Application number: 2023/93693	
What is the application for?:	Change of use of warehouse to dwelling and erection of extension and alterations
Address of the site or building:	19-21, Low Town, Kirkburton, Huddersfield, HD8 0SB
Postcode:

Type of comment: An objection	
Do you wish your comments to be published on the website anonymously?	No

(E) South as Proposed
 1 : 100

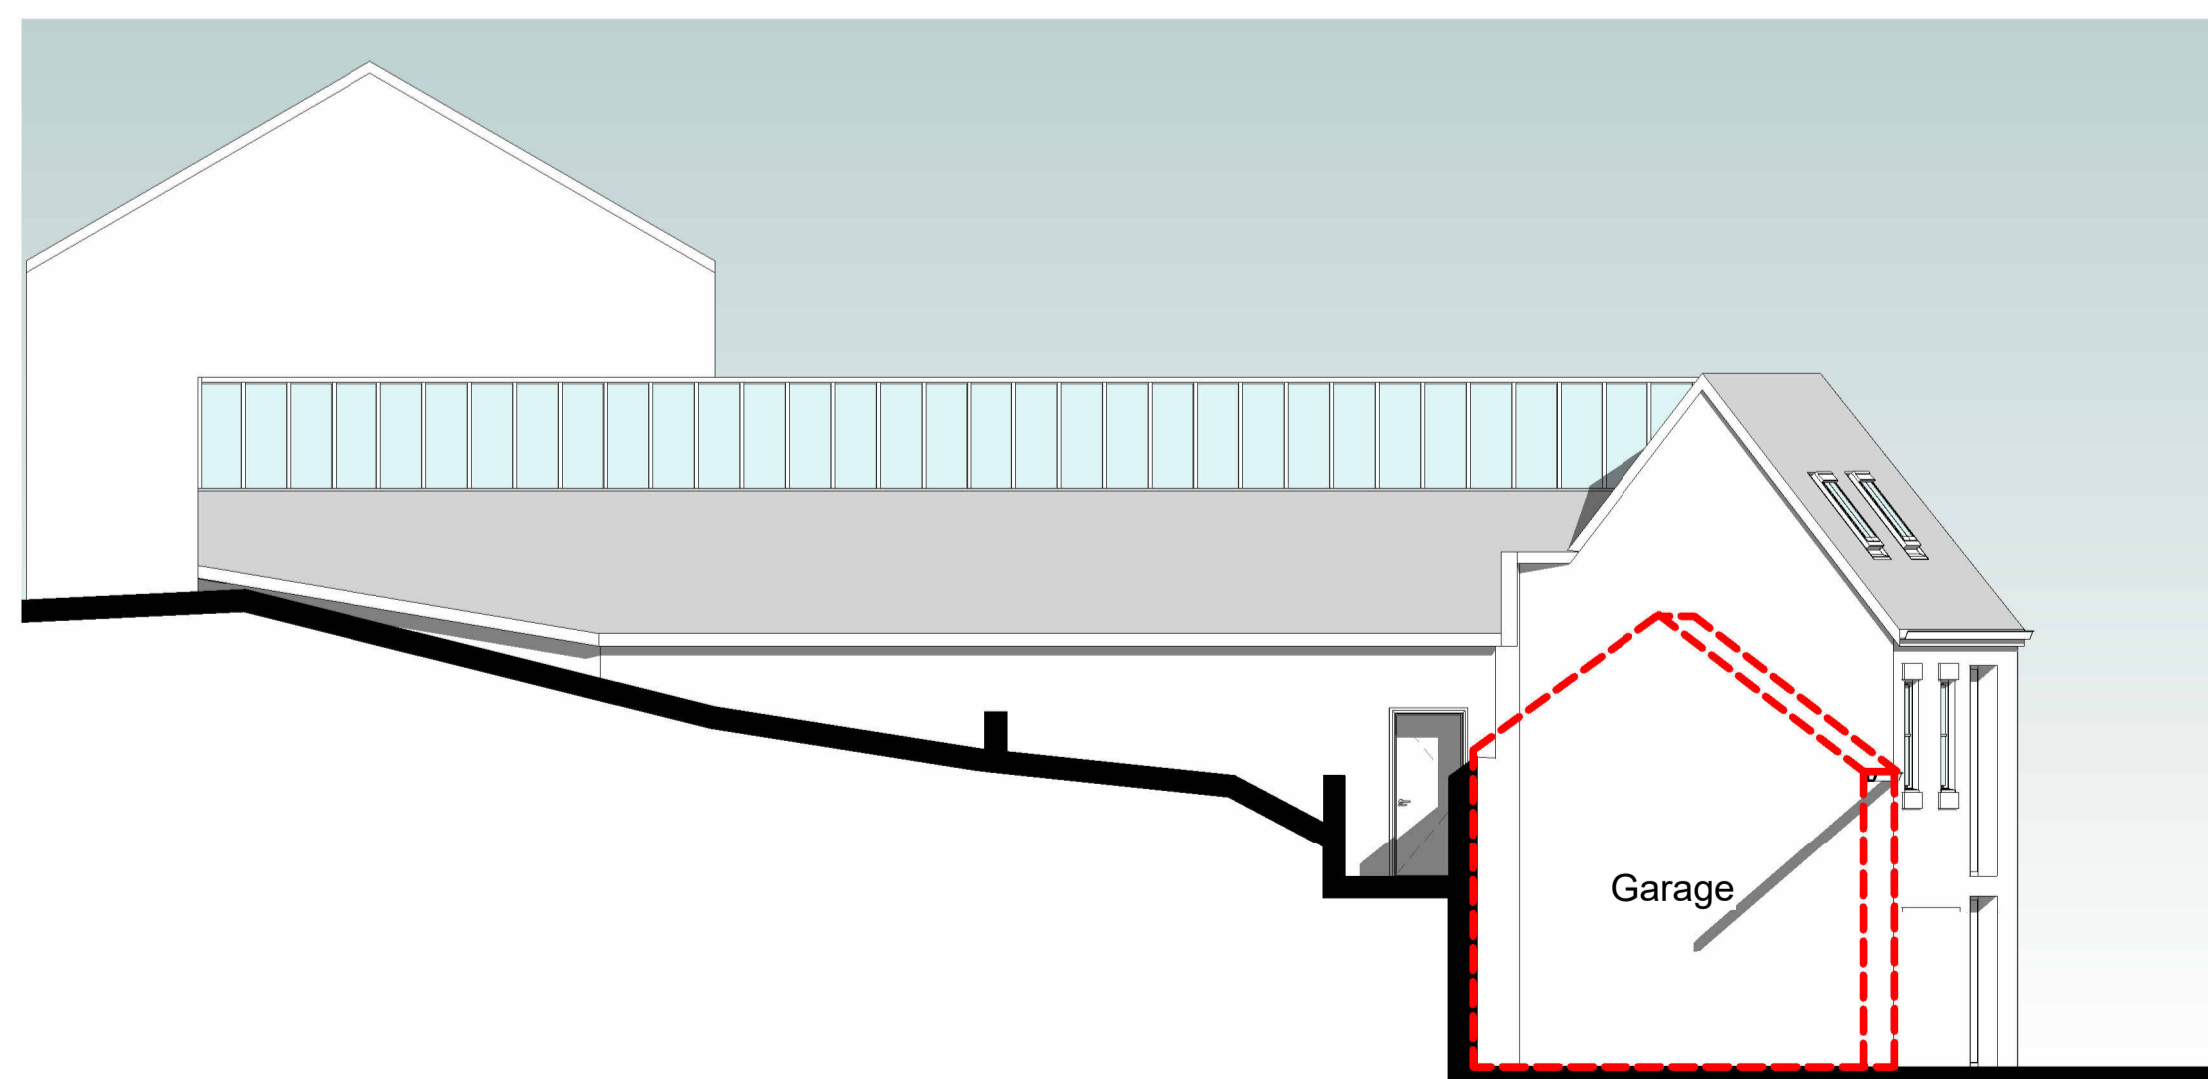
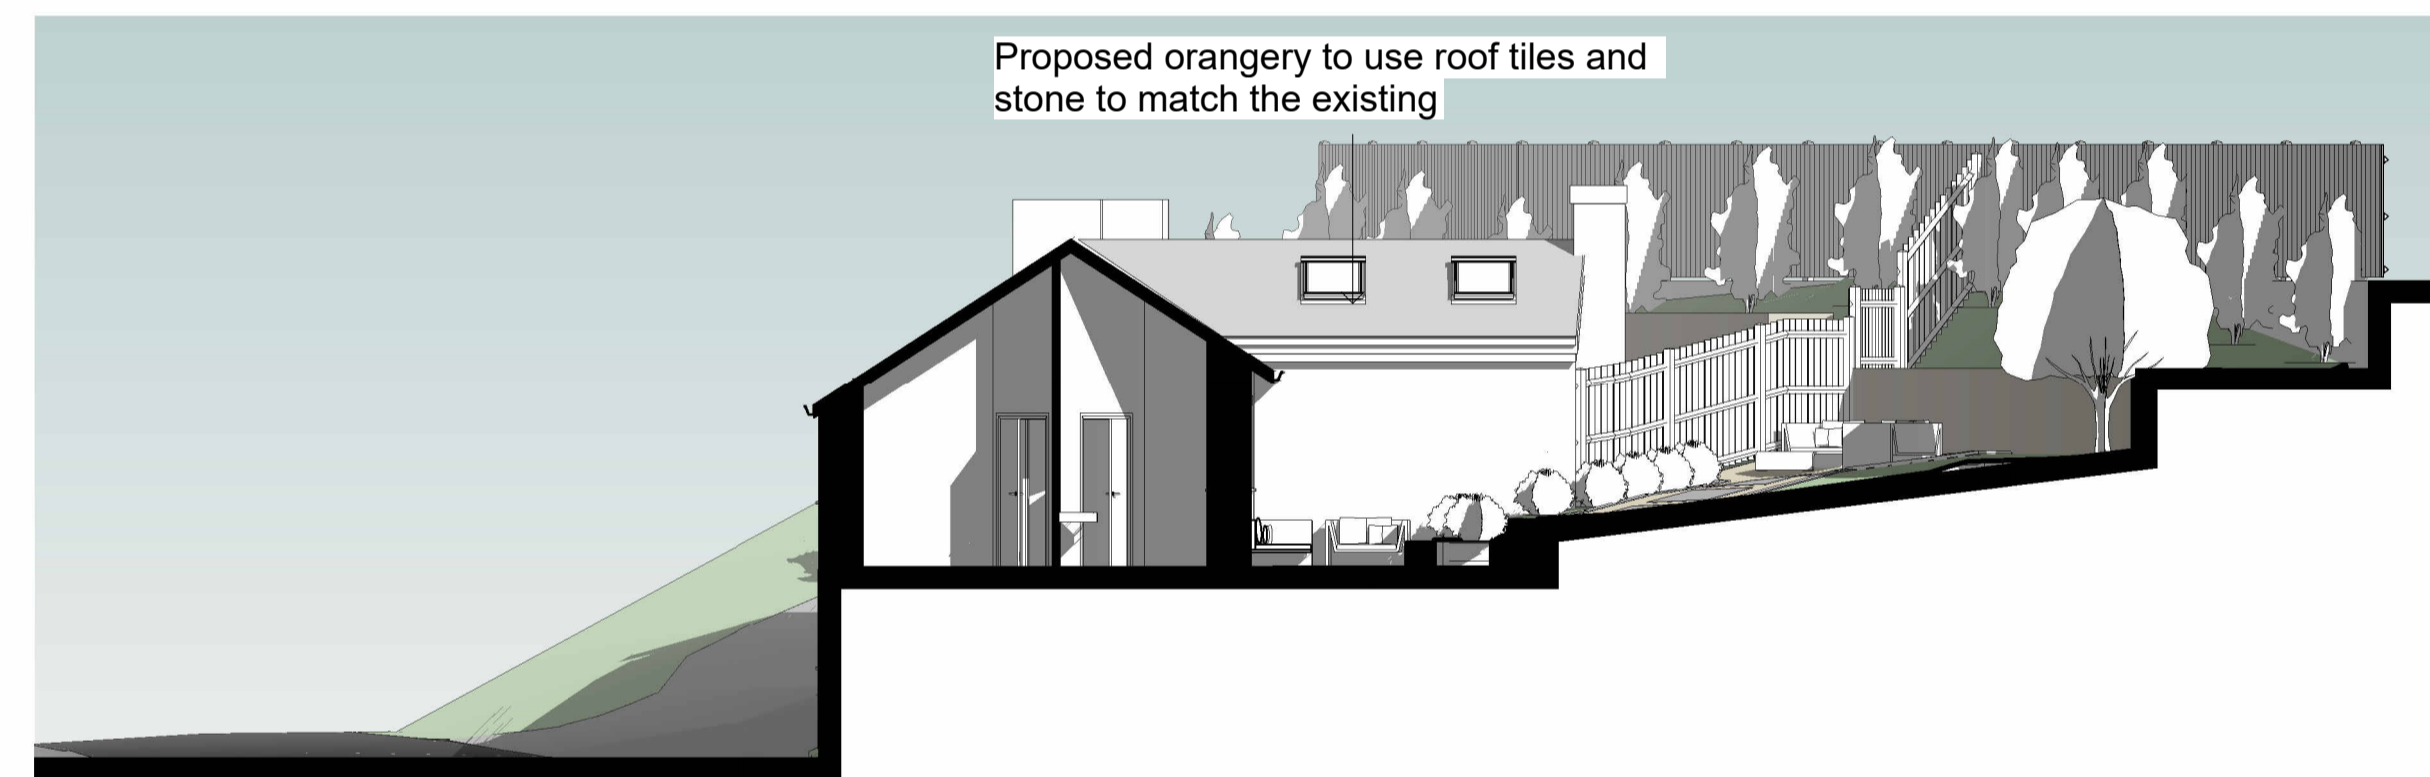
The proposed design retains the existing doorway on the south side at the top of the external steps. This door was necessary for the original use of the baths, a use which ceased circa 1950, when the building was converted into a warehouse. We understand the use as a warehouse ceased in the early 1970's, and it's been empty ever since. Residents of the cottages accessed the property from an external door on the north side, situated in the garden of the cottages. As such the door on the south side has not been used as a regular access point in over 50 years.

The proposed change of use to a residential dwelling would allow residents & visitors to use the existing door to access the property. This would require residents to enter through our gate into our outside space and cross our patio area to get to the external steps that lead to the doorway. Residents could also use the steps and space at the top of the steps to sit. If the property was used as a residential dwelling, this could take place at any time of day or night and at weekends.

We are supportive of the development in principle but must object to the impact on our privacy of retaining the now unnecessary existing doorway to the south side. Our preference would be for the development to go ahead, but with the removal of the existing southside doorway at the top of the steps. This would allow for all of the positive elements of this proposal to be realised, Without the resulting invasion of privacy and reduction in amenity for us.
